Meadowlake Industrial Park
Filing No. 1 Preliminary Plan
Traffic Impact Study
(LSC #S234040)
September 24, 2023

Add PCD File No. SP236 ¹

LSC responses to TIS Redline Comments

Figure 3  
Existing Traffic, Lane Geometry,  
Traffic Control, and Level of Service  
Meadowlake Industrial Park Filing No. 1 Preliminary Plan (LSC #S234040)

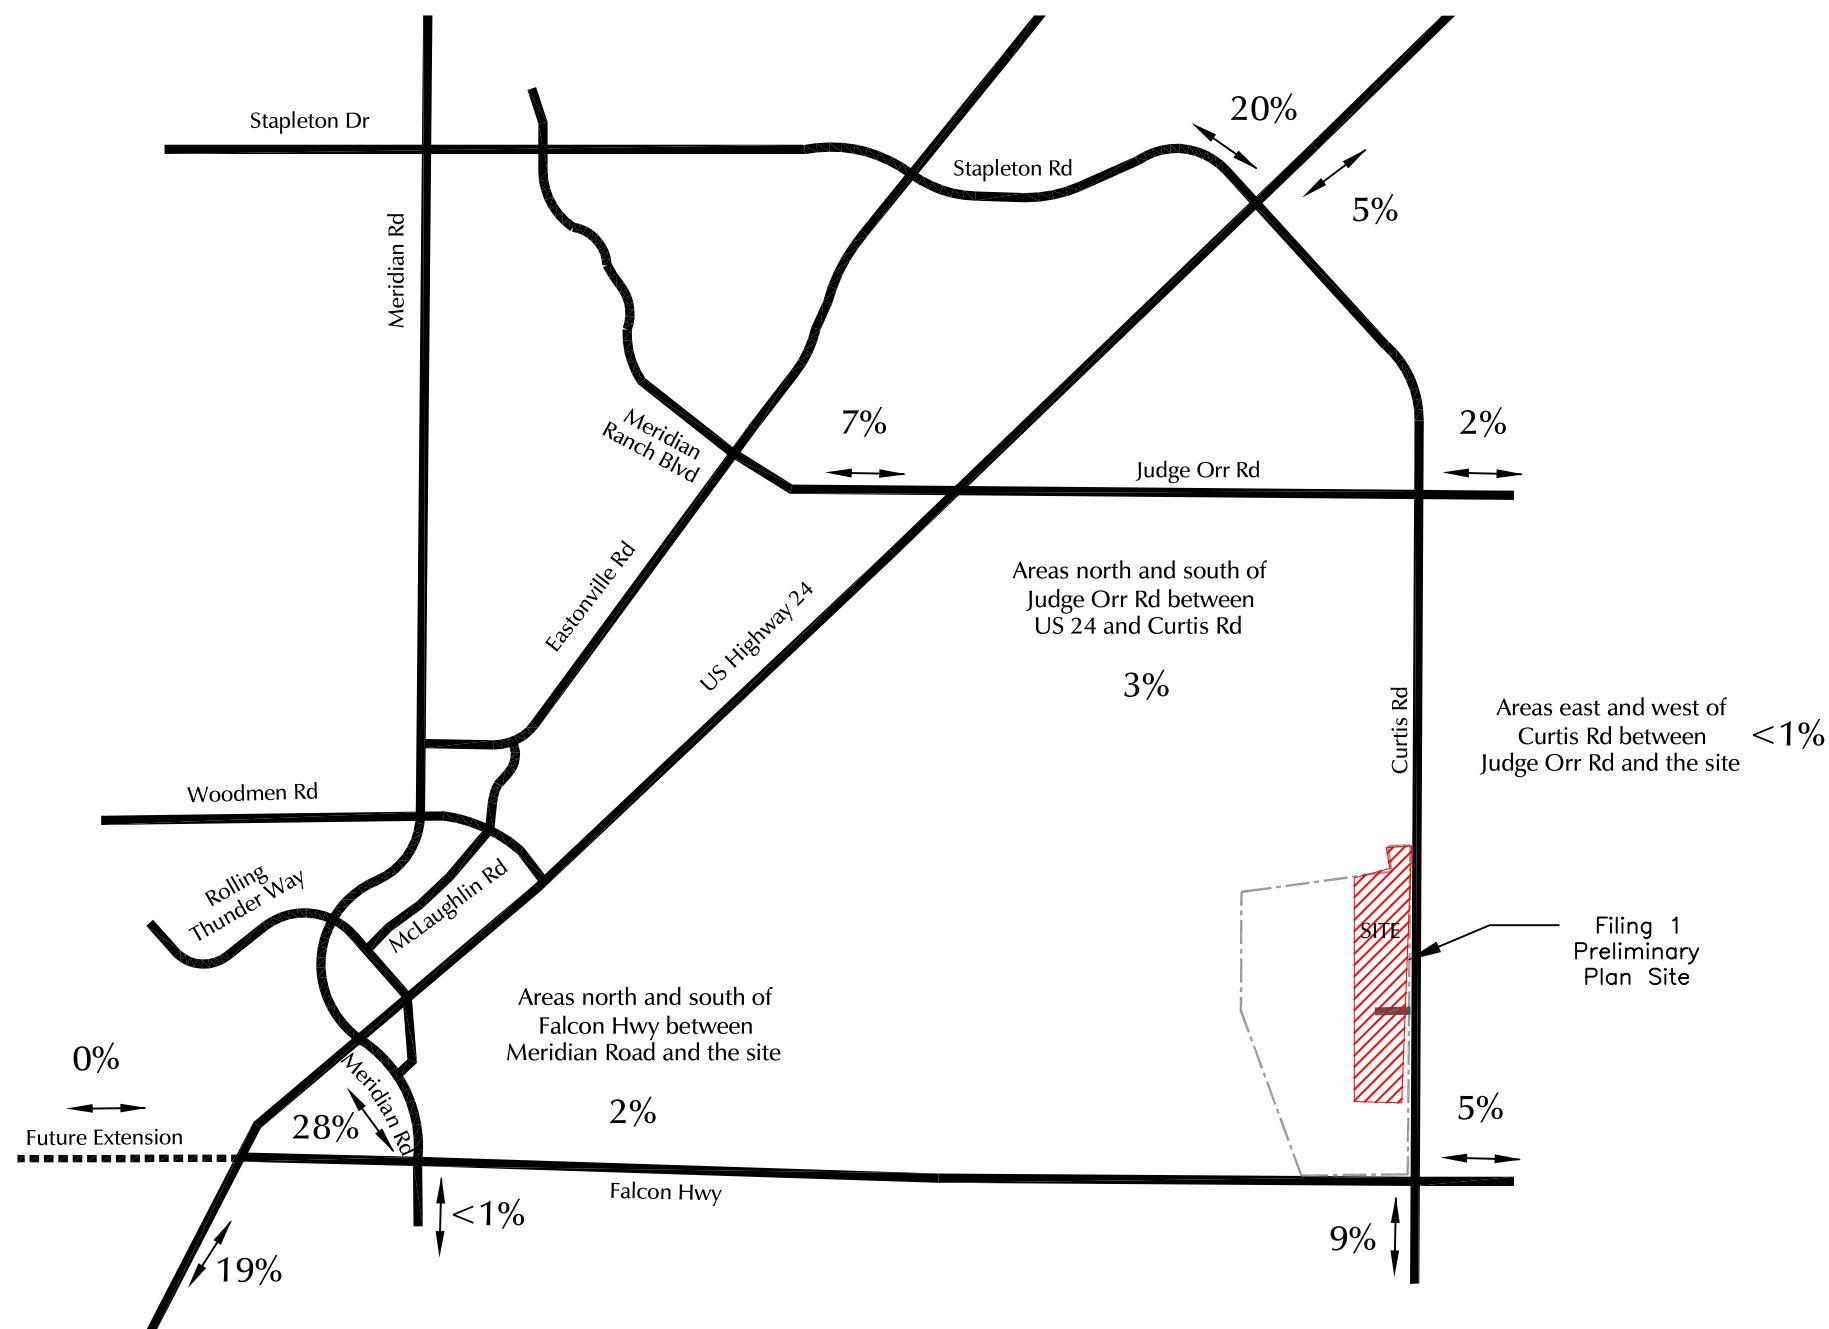
figures 3a & 3b do not provide the LOS. Please verify and update all figures so that they correspond to the correct information indicated in the narrative. Add complete titles to each of the figures so that it is clear what condition is being represented.

LSC Response: The updated TIS contains new and revised figures with changes to the numbering.

Figure 4

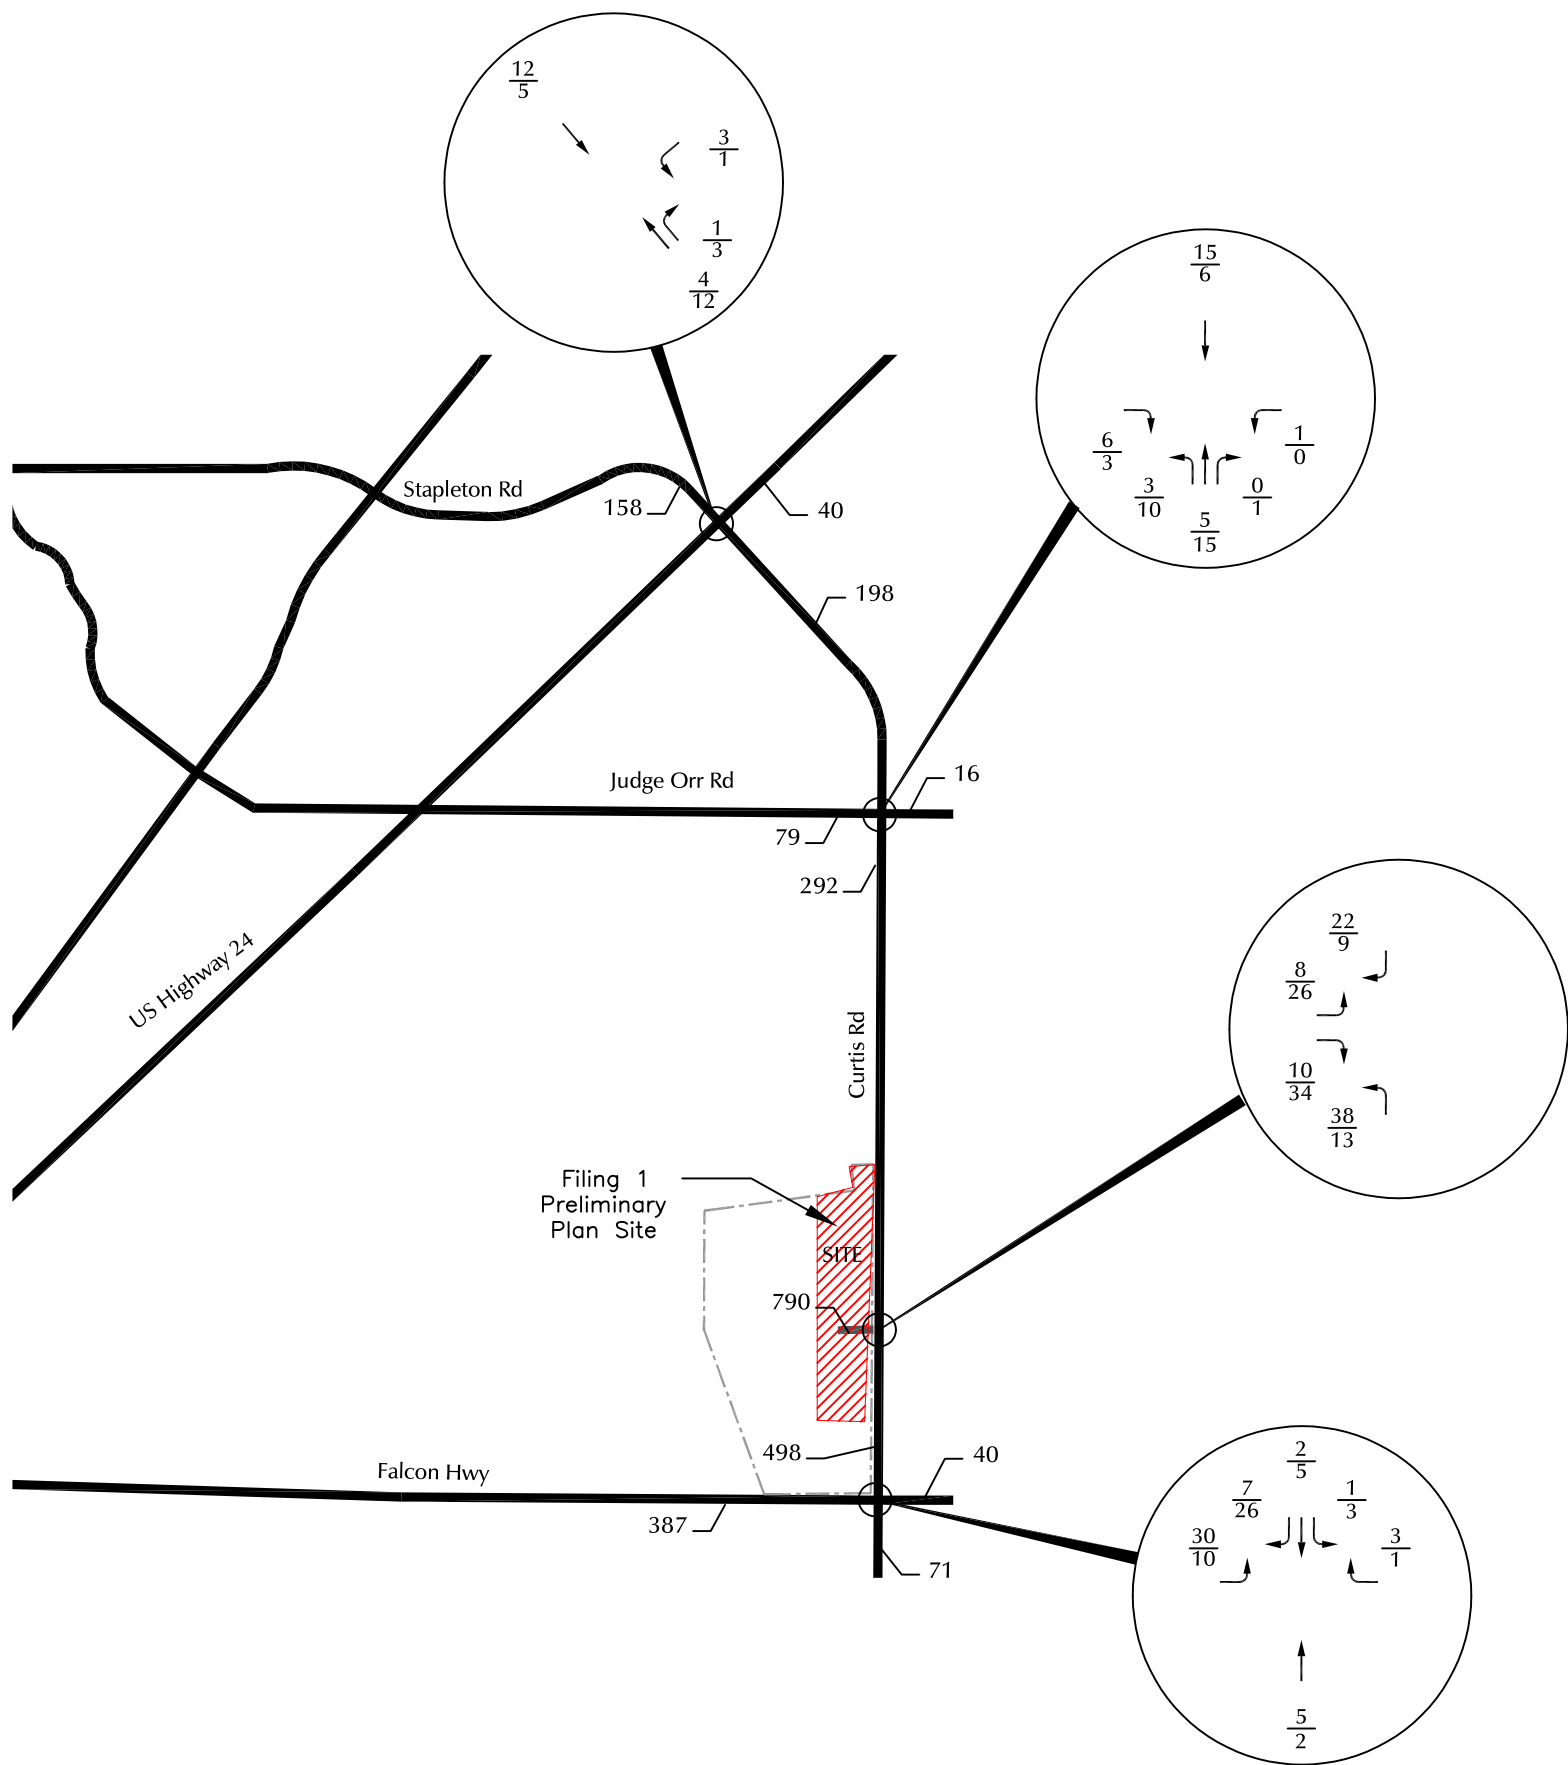
[4a](#)

LSC Response: The updated TIS contains new and revised figures with changes to the numbering. Figure 4 is now correct as the new TIS has the short-term distribution shown on Figure 4.

Figure 5  
**Short-Term Site-Generated Traffic**  
 Meadowlake Industrial Park Filing No. 1 Preliminary Plan (LSC #S234040)

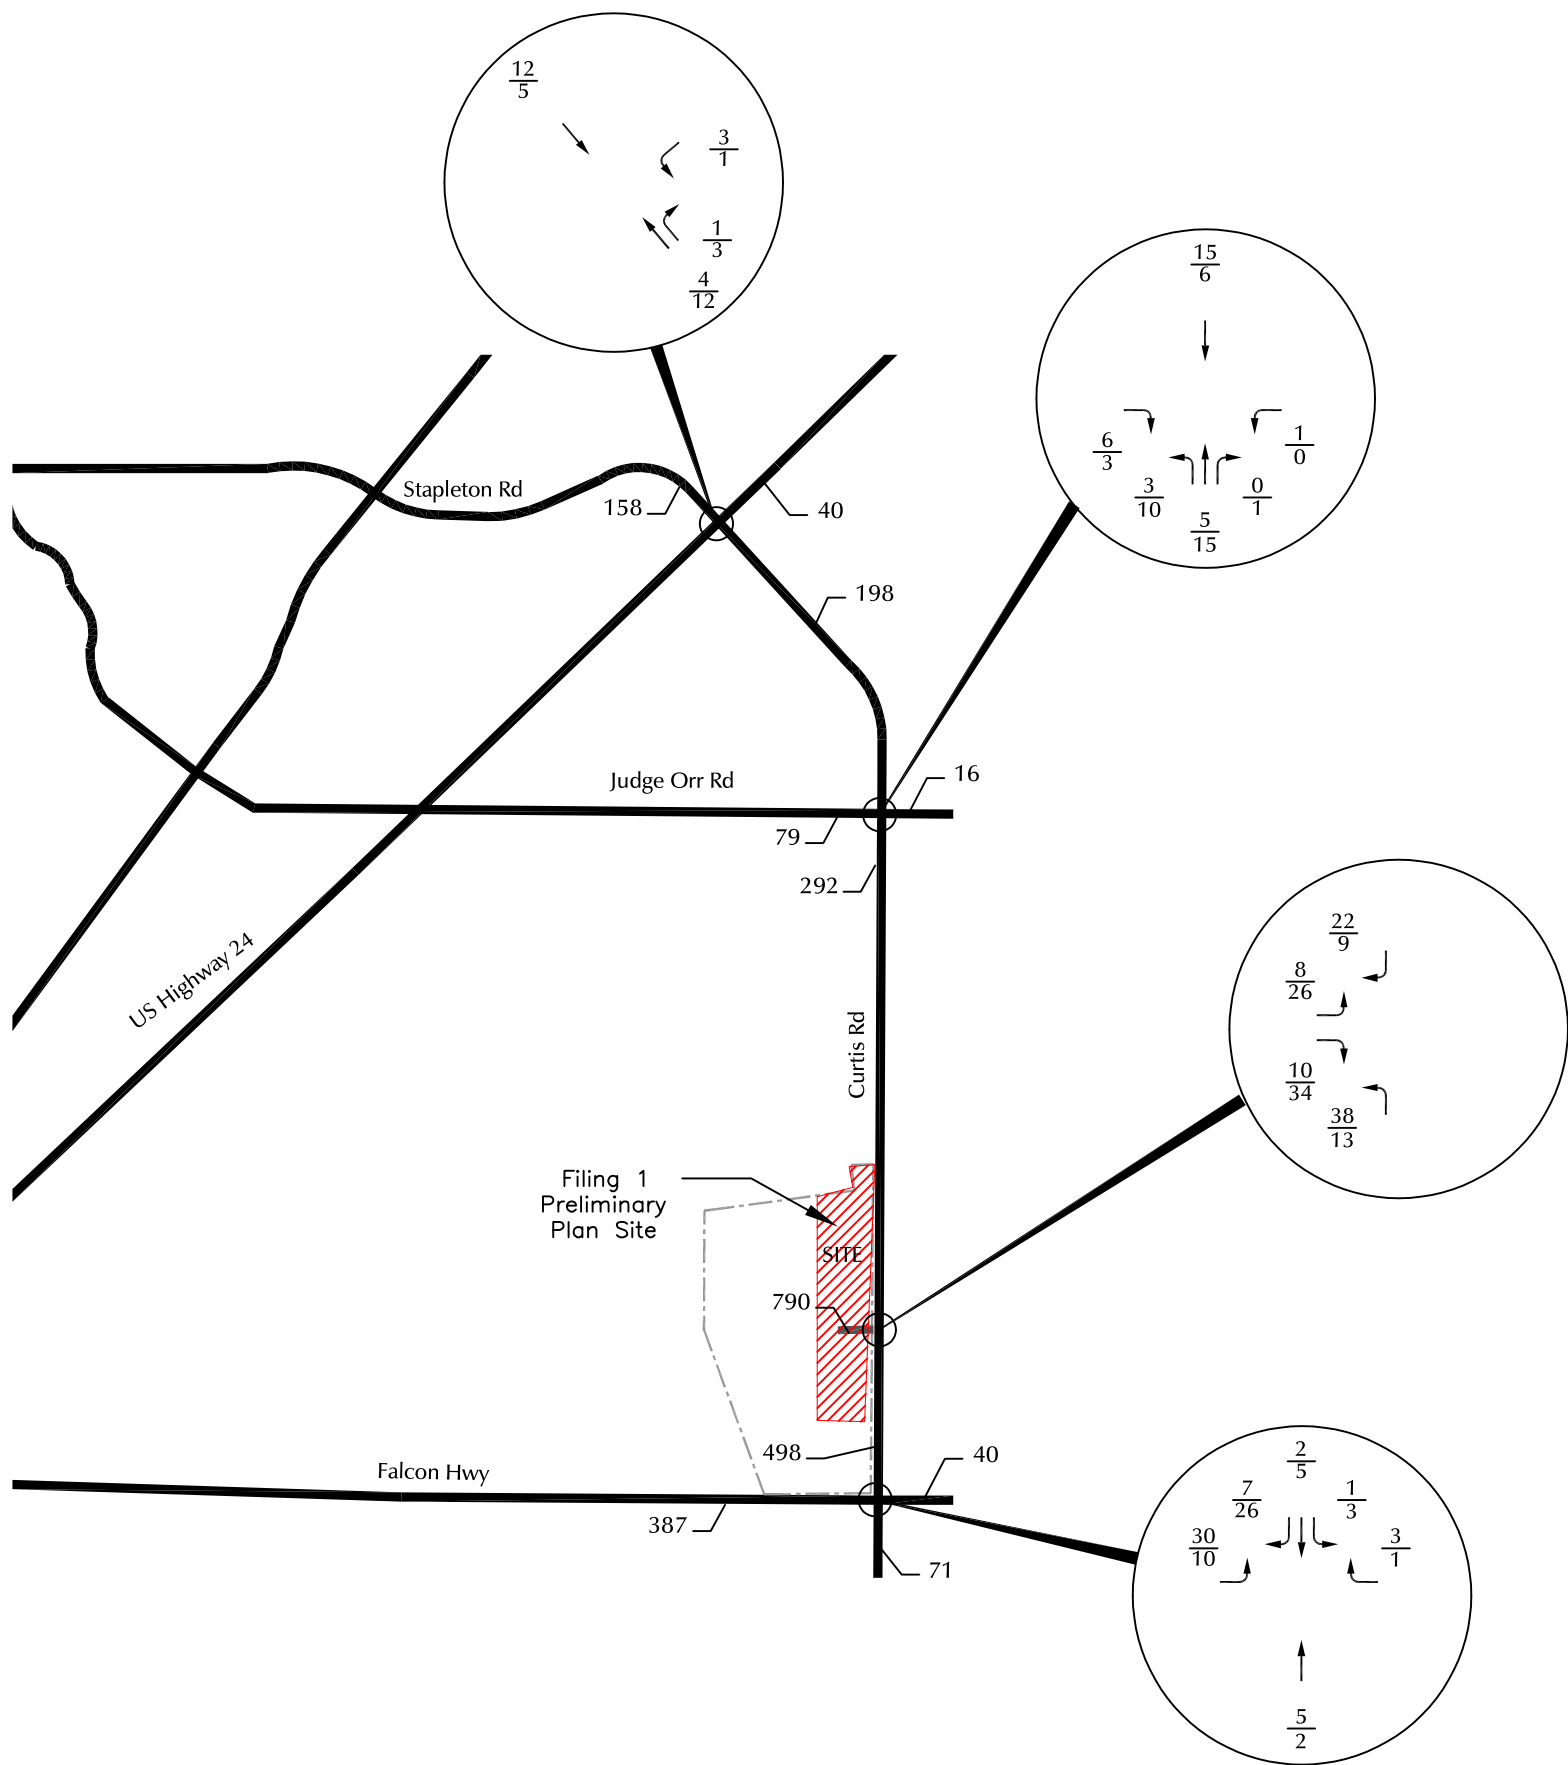
There is no figure 5 in the appendix. Revise to provide figure.

[figure 5 has not been provided](#)

Author: jchodsdon Subject: Sticky Note Date: 2/2/2024 17:35:58
LSC Response: The updated TIS contains new and revised figures with changes to the numbering.

LSC Response: The updated TIS contains new and revised figures with changes to the numbering.
